**RE: Modwash - Eubank
Conceptual Grading & Drainage Plans
Engineer's Stamp Date: 03/24/23
Hydrology File: K20D060**

Based upon the information provided in your submittal received 03/17/2023, the Conceptual Grading & Drainage Plan is preliminary approved for action by the Development Hearing Officer (DHO) on Preliminary Plat/Final Plat.

**RE: Modwash - Eubank
Grading & Drainage Plans
Engineer's Stamp Date: 02/07/23
Hydrology File: K20D060**

SHEET NUMBER:
C-103

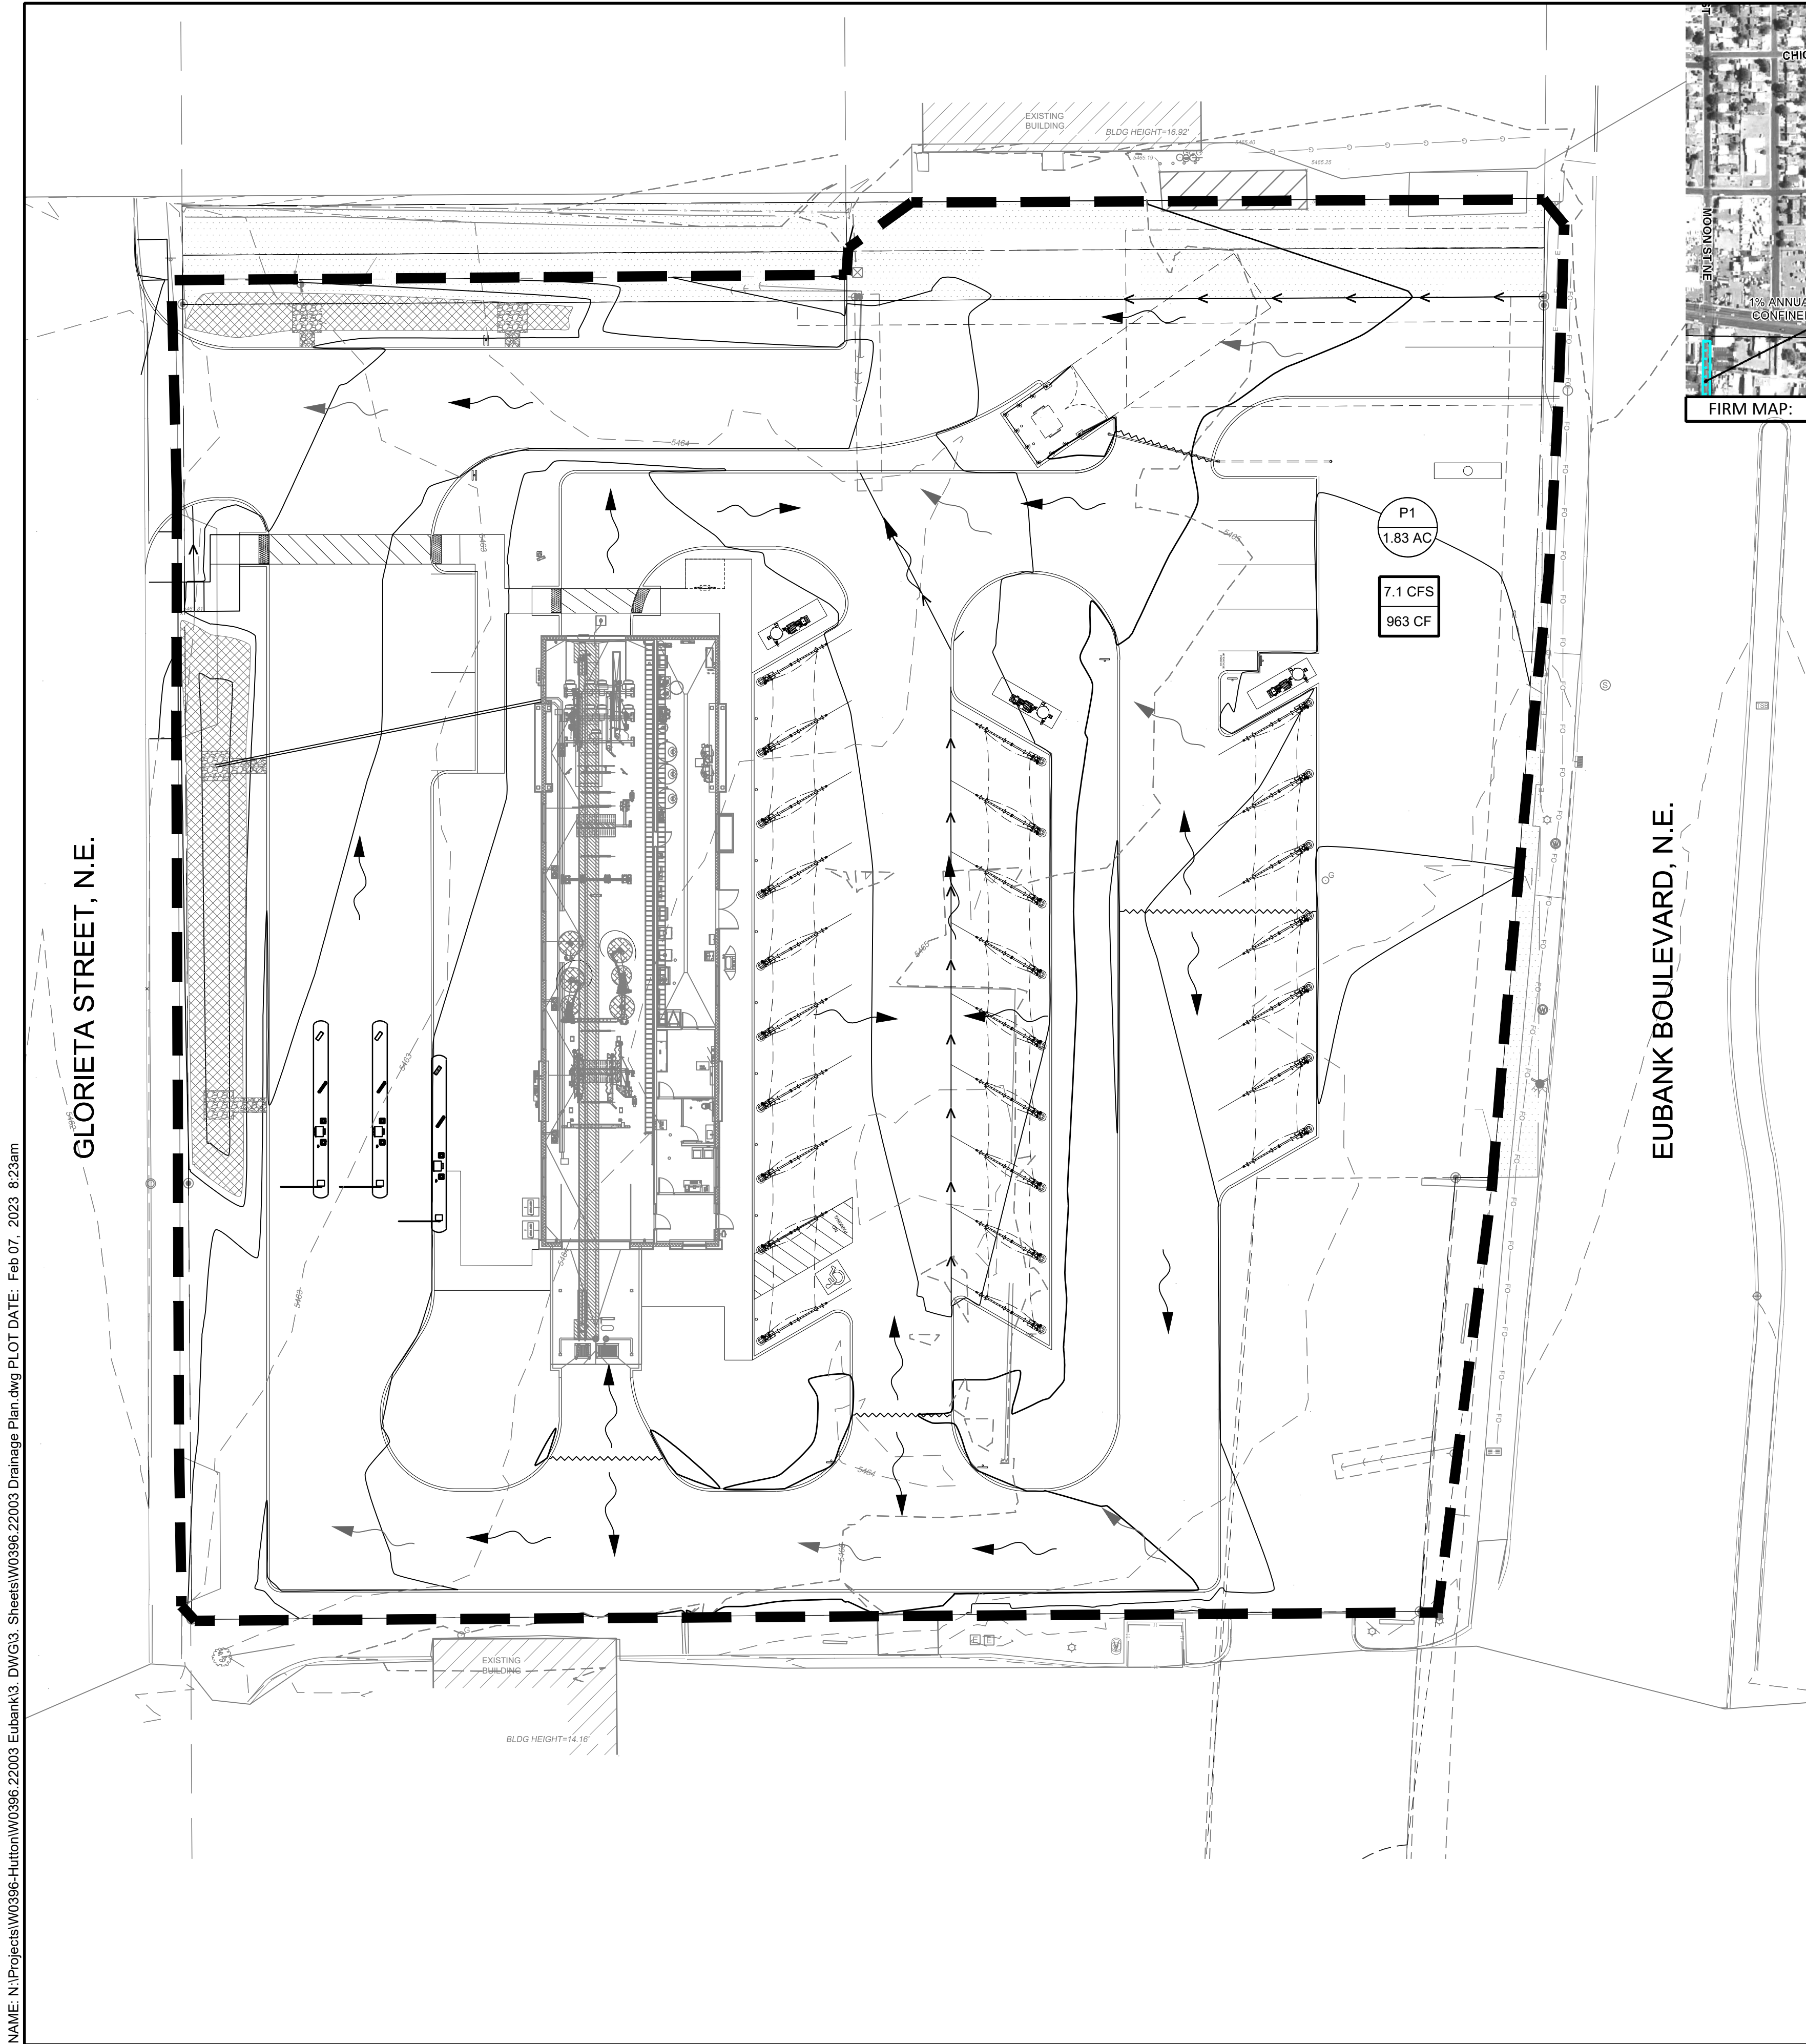
2. On Sheet C-103, Please ensure that the drainage flow arrows match the drainage flow arrows on Sheet C-104. There are a few that do not match. [I could not find any developed condition drainage flow arrows on sheet C-103 that conflicted with the slope labels on Sheet C-104. Please note that the slope arrows on sheet C-104 are provided to help the contractor visualize the longitudinal slope and cross slope of the drive aisles. These slope labels are not intended to be drainage flow arrows.](#)

5. On Sheet 103, please provide the weir calculations, per DPM Article 6-16(A), for the curb cuts and sidewalk culverts. A coefficient of 2.7 is typically used for the weir equation $Q = CLH^{2/3}$. [Revised.](#)

C-104

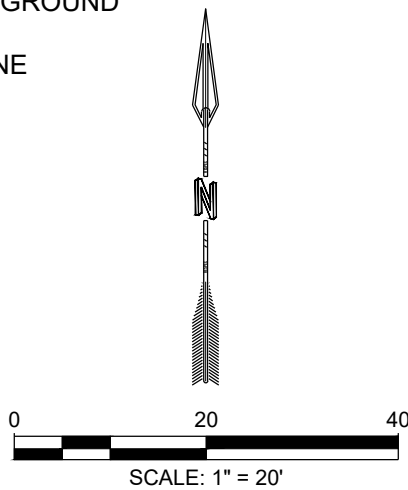
6. On Sheet 104, please specify the curb cut width in Key Note #2. [Revised.](#)
7. On Sheet 104, please provide a sidewalk culvert for the spillway for the stormwater quality pond along Glorieta St. and label per CoA Detail 2236. [Revised.](#)

8. On Sheet 104, please provide the SO-19 Standard Notes, latest version. [Revised.](#)
